CITY OF ALBUQUERQUE

November 16, 2018

**RE: Apartment Urban Living @ Nob Hill
Central and Montclair NE
Conceptual Grading Plan Stamp Date: 11/12/18
Drainage Report Stamp Date: 10/29/18
Hydrology File: K17D073**

CG-101

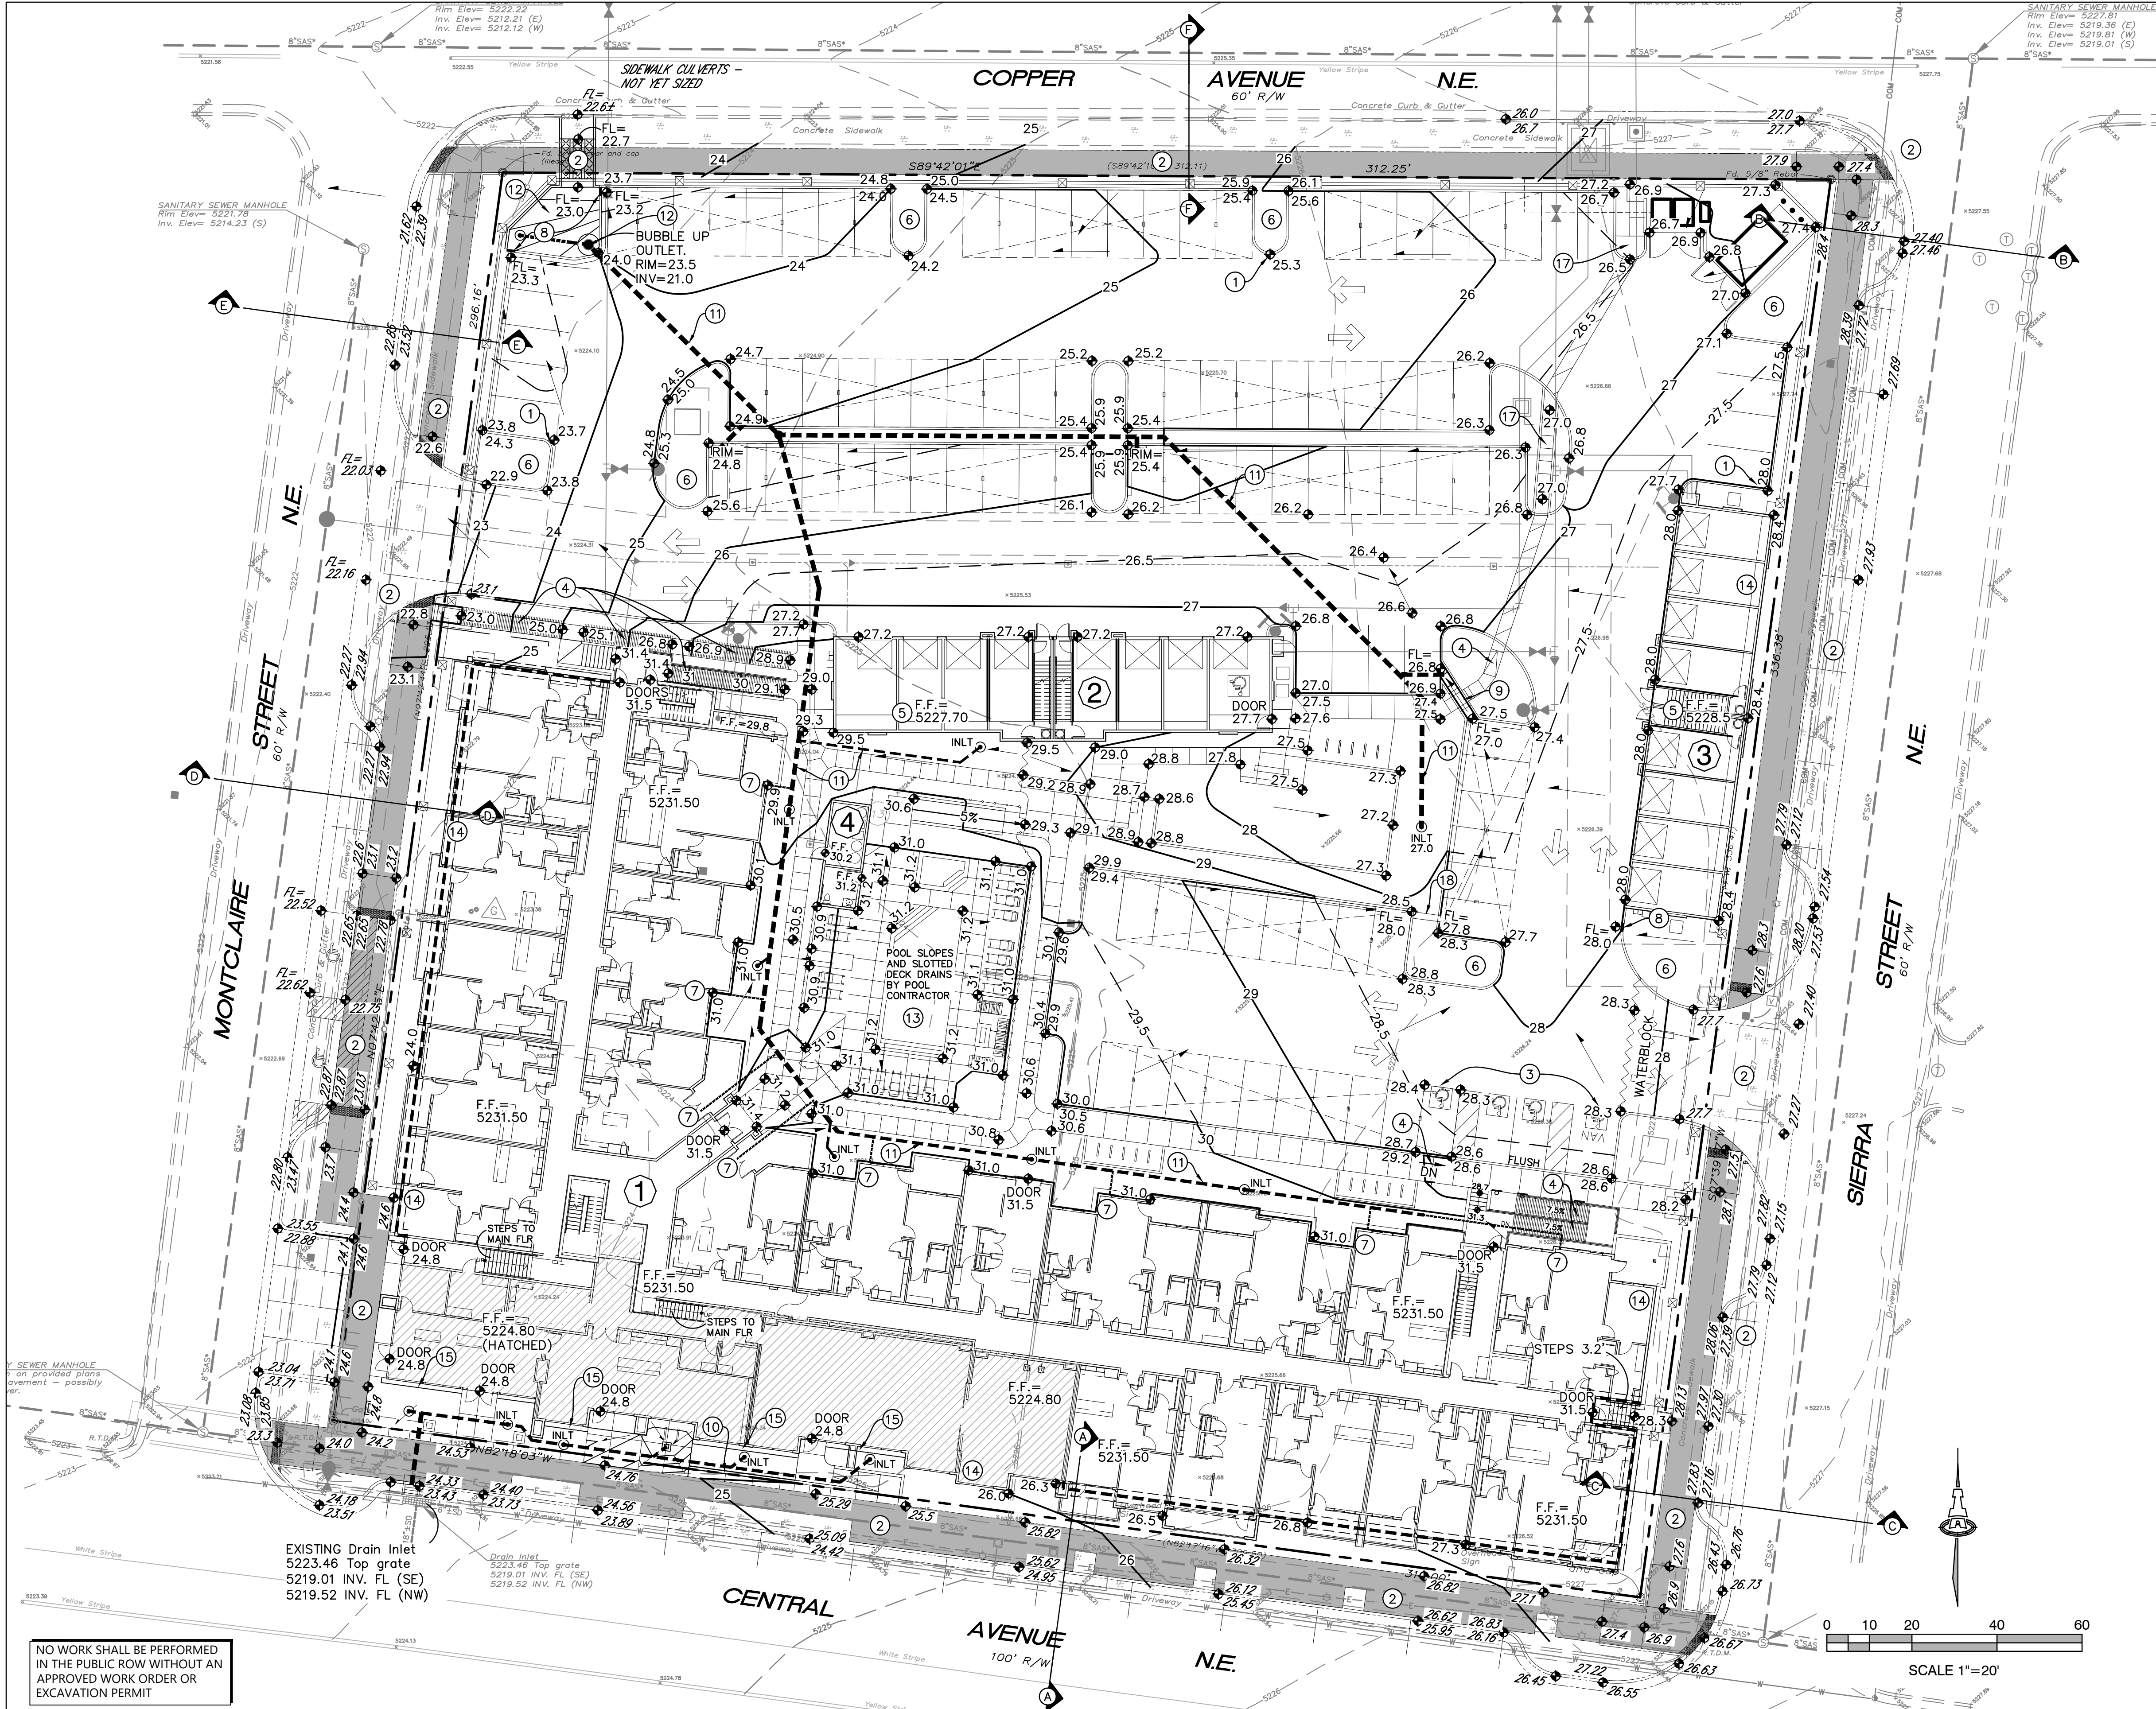
- b. Pond rating curve and routing of the 100-yr event. Also show the 100-yr water surface on the grading plan.
 - c. The HGL calculations need to use the maximum water surface elevation above the bubble-up grate as the downstream starting EGL.
